TO	Nicole Brewer, Director, Energy Assessments
FROM	Mark Davey
DATE	17 July 2026
OUR REFERENCE	0617753
SUBJECT	Keri Keri Wind Farm (SSD-3858962) Request for Additional Information

Keri Keri Wind Farm (SSD-3858962)–Request for Additional Information

Ref No	Theme	Submission	Response	Where Addressed
TfNSW-01	Traffic (generation)	1. Preconstruction Minor Works for workers accommodation camp traffic assessment requirements. A complete assessment of the wind farms and workers' accommodation camp construction pre-construction minor works is required and is to include: - Assessment of traffic volumes and identification of the types of vehicles that will be used during this period, including the largest design vehicle. - Perform a swept path analysis for the largest heavy vehicle at the existing intersection, ensuring it can navigate within the current pavement. If the design vehicle cannot turn easily, implement necessary mitigation or temporary works. - Assess existing Safe Intersection Sight Distance (SISD) and propose measures to achieve compliance, - Identify AM/PM peak hour traffic volumes and proposed volumes during this time. Traffic volumes during the AM/PM peak hours are to be c

DRAWN: OM
 DATE: 20/05/2026
 DWG NO: 1652 RA01C
 SCALE at A3: NTS

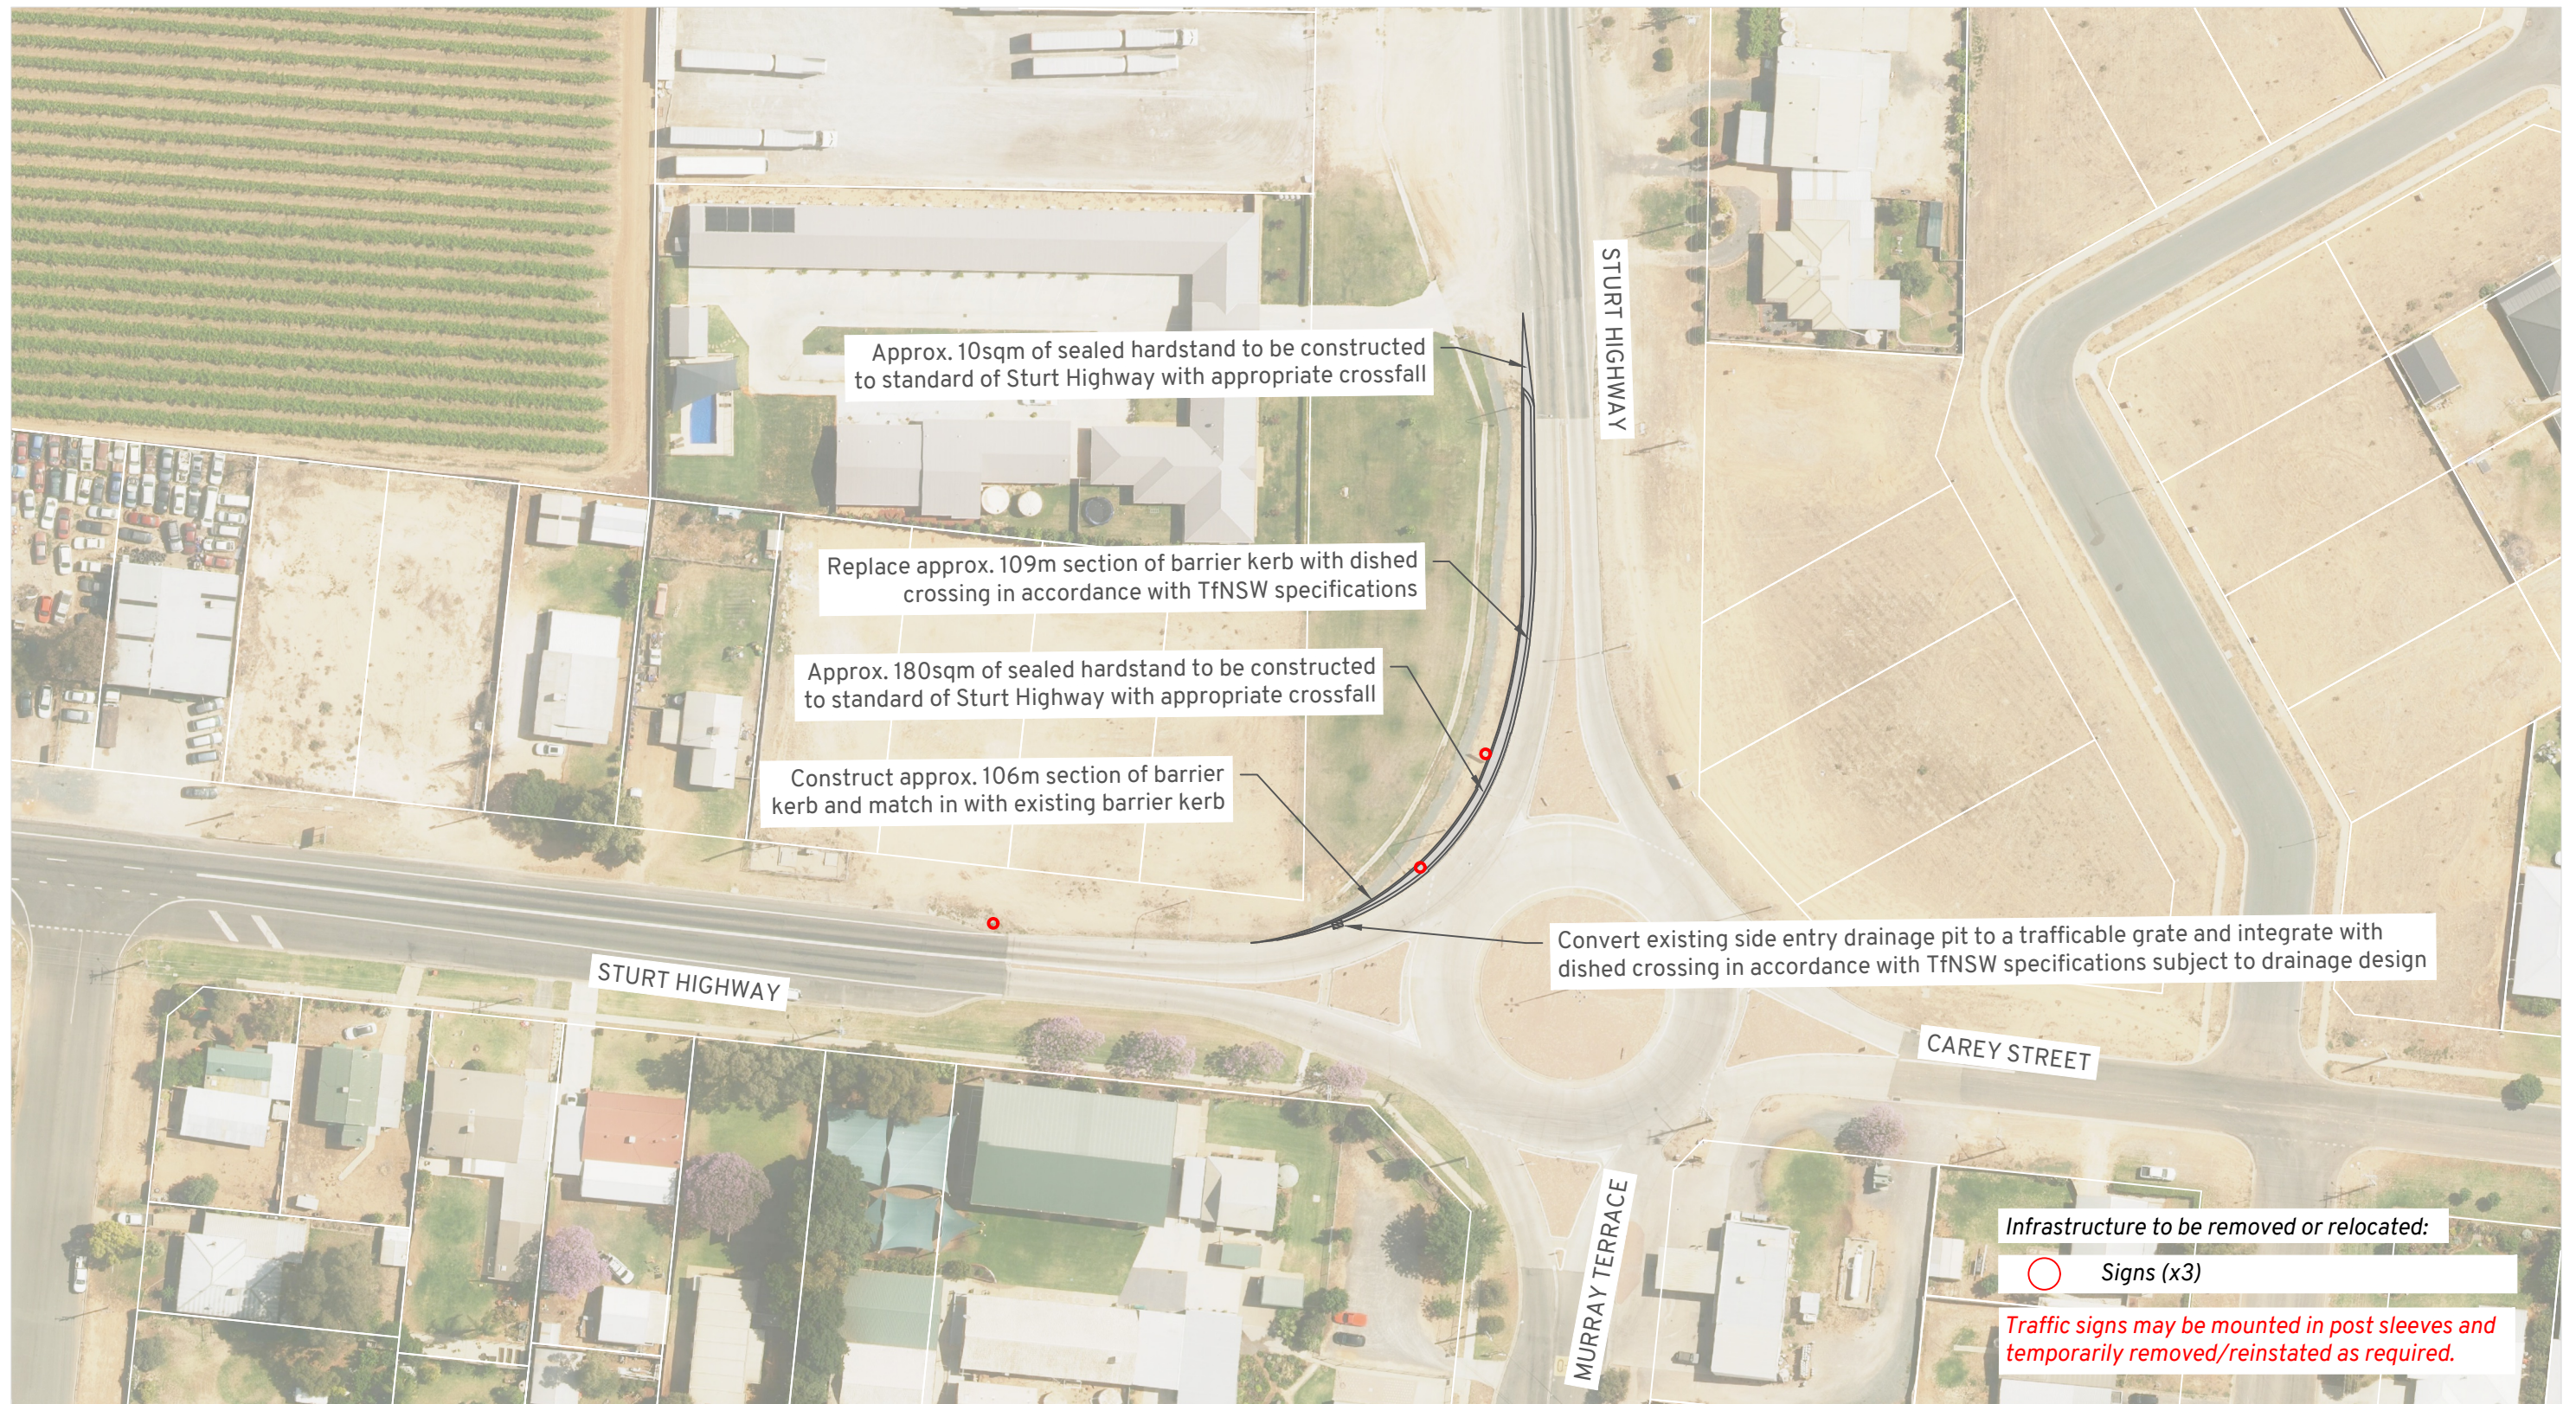
c. Revision D, Civil Design, RJ Andrews SPA - Sturt Highway at Balranald - TfNSW preference is to maintain the current intersection configuration with medians and kerb and channel. Revised strategic concept designs required that references to the barrier kerb be removed and replaced with a roll-over kerb to facilitate movements onto the hardstand. d. Drainage pits will need to be assessed and made trafficable as required. To be annotated on the strategic concept designs.	Revised strategic concept design for this intersection is provided in Appendix A (Sheets 04-07). The design includes a dish crossing with trafficable grates to facilitate movements onto the hardstand area.	Appendix A (sheets 04-07) of the Amended TIA (Attachment D)

j. Revision D, Civil Design, 21012CAD003 Figure 5 - TfNSW preference is to maintain the current intersection configuration with medians and kerb and channel. Please replace the barrier kerb with a roll-over kerb to facilitate movements onto the hardstand. Drainage pits will need to be assessed and made trafficable as required. - Where the raised island is proposed to be removed, TfNSW's preference is to retain this island and make parts of or the whole length trafficable.	Revised strategic concept design for this intersection is provided in Appendix A (Sheets 04-07). The design includes a dished crossing with trafficable grates to facilitate movements onto the hardstand area, as well as strengthening of the impacted traffic island.	Appendix A (sheets 04-07) of the Amended TIA (Attachment D)
